## **LEAD LOCAL FLOOD AUTHORITY CONSULTATION – STATUTORY CONSULTEE**

**Consultation on Application Number: 2017/91677**

**Address: Land at, Serpentine Road, Cleckheaton, BD19 3NA**

**Proposal: Erection of 42 retirement living apartments, 83 bed care home with provision of communal facilities, landscaping and car parking and erection of 7 affordable dwellings**

Drawing title  
**Drainage Strategy Layout**

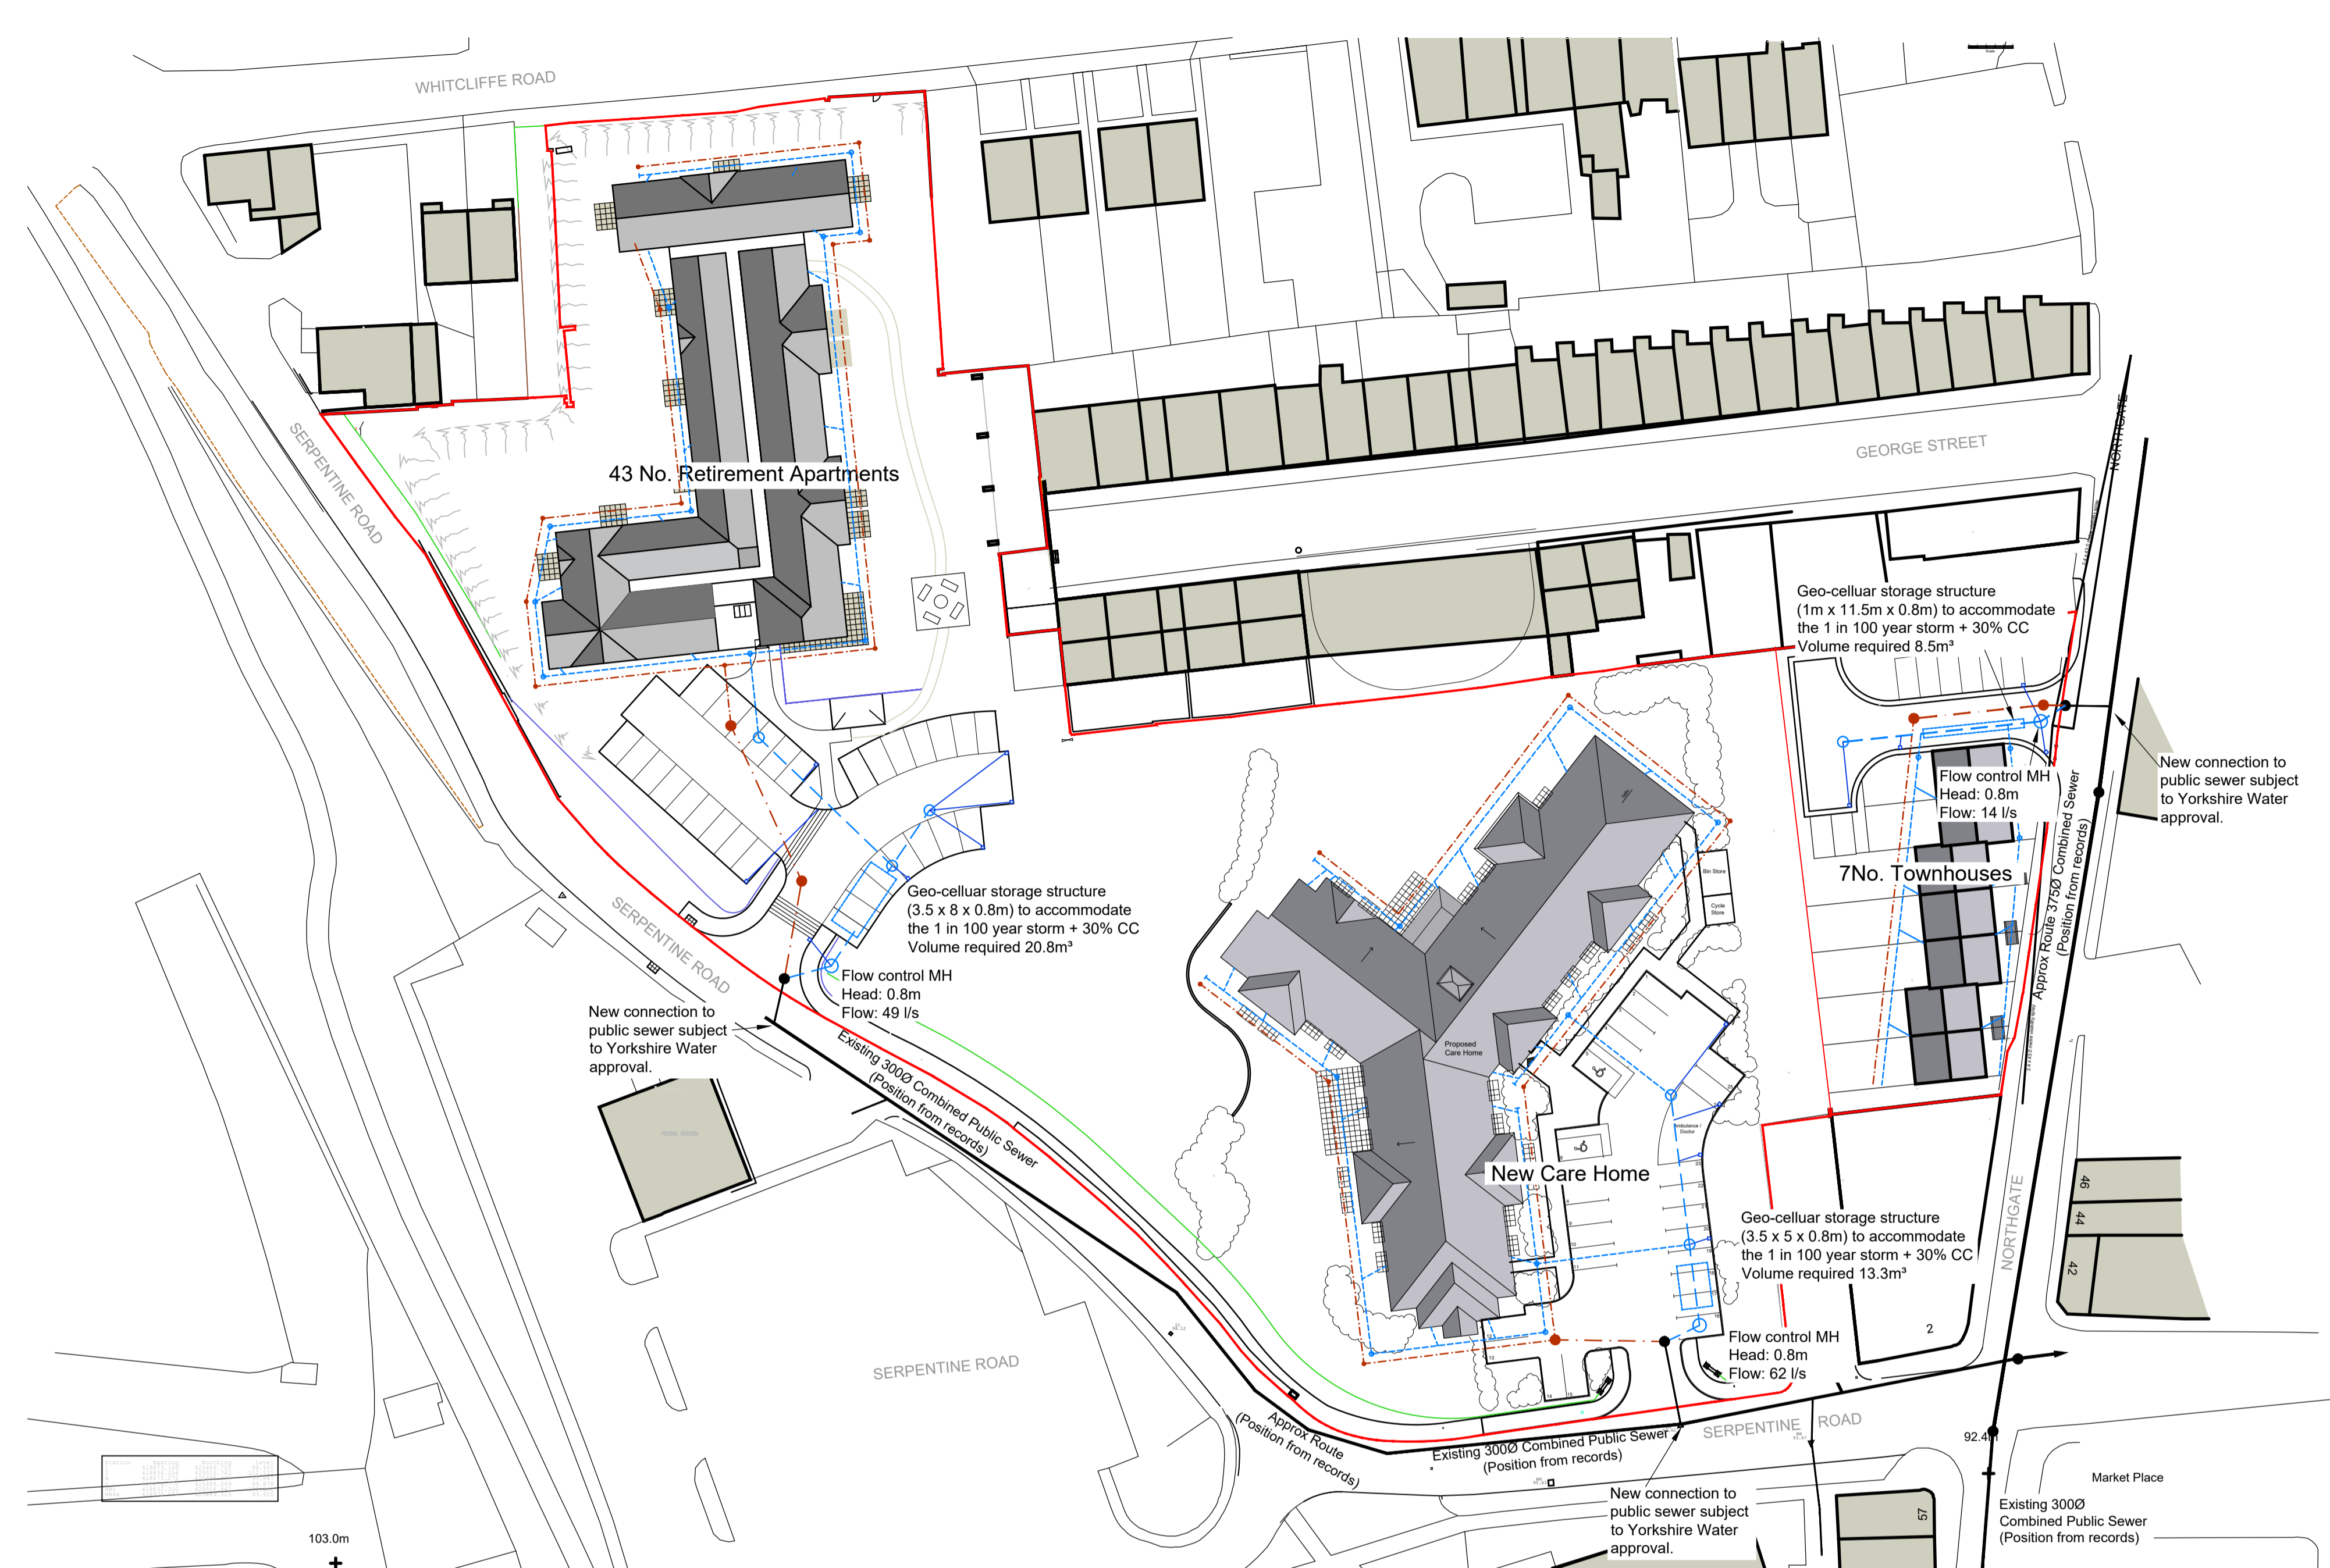
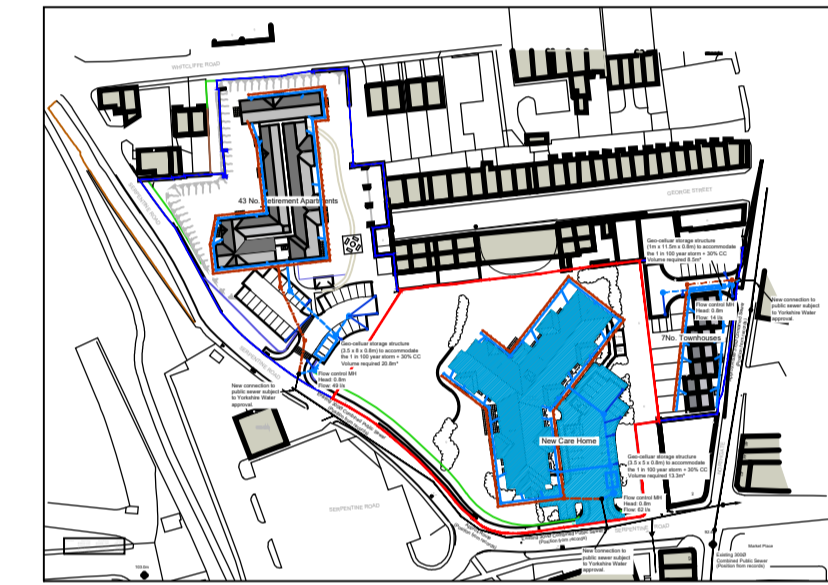
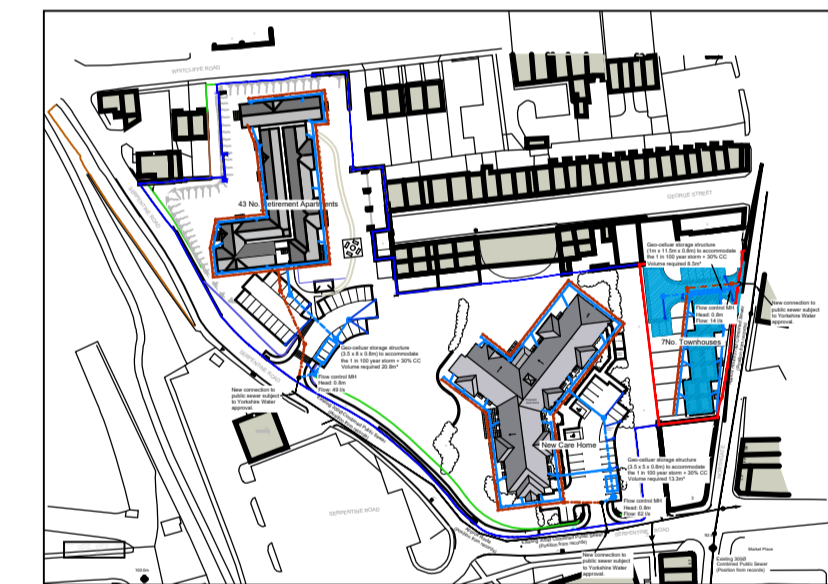
We therefore dispute the indicative drainage drawing supplies showing 49l/s, 14l/s and 62l/s = total 125l/s to the public combined sewer. We expect this figure to be lower. If however Yorkshire Water agrees a set figure to public combined sewer, then we advise the LPA that they have accepted the risk. They currently asked for evidence.

**Figure 1.4 - Risk of Flooding from Surface Water Mapping**

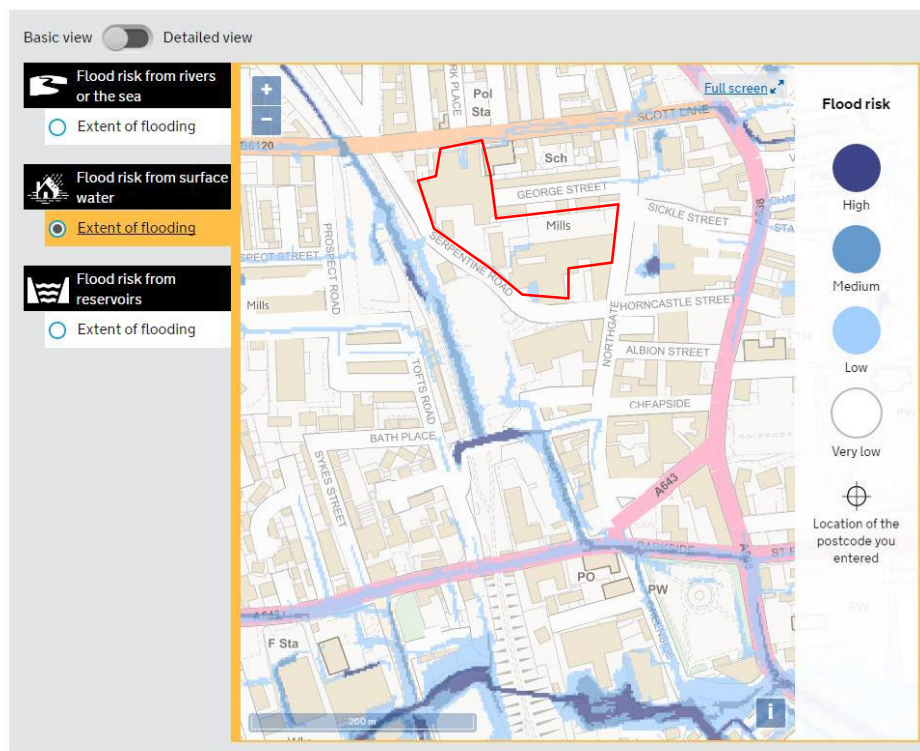
Risk from sewer flooding to site, and that of short intense rainfall on local road networks should be based on the assumption that pipework is surcharging or gullies

are not receiving the water. An assessment of whether the topography puts a risk on the site and how this risk may change upon development is needed.
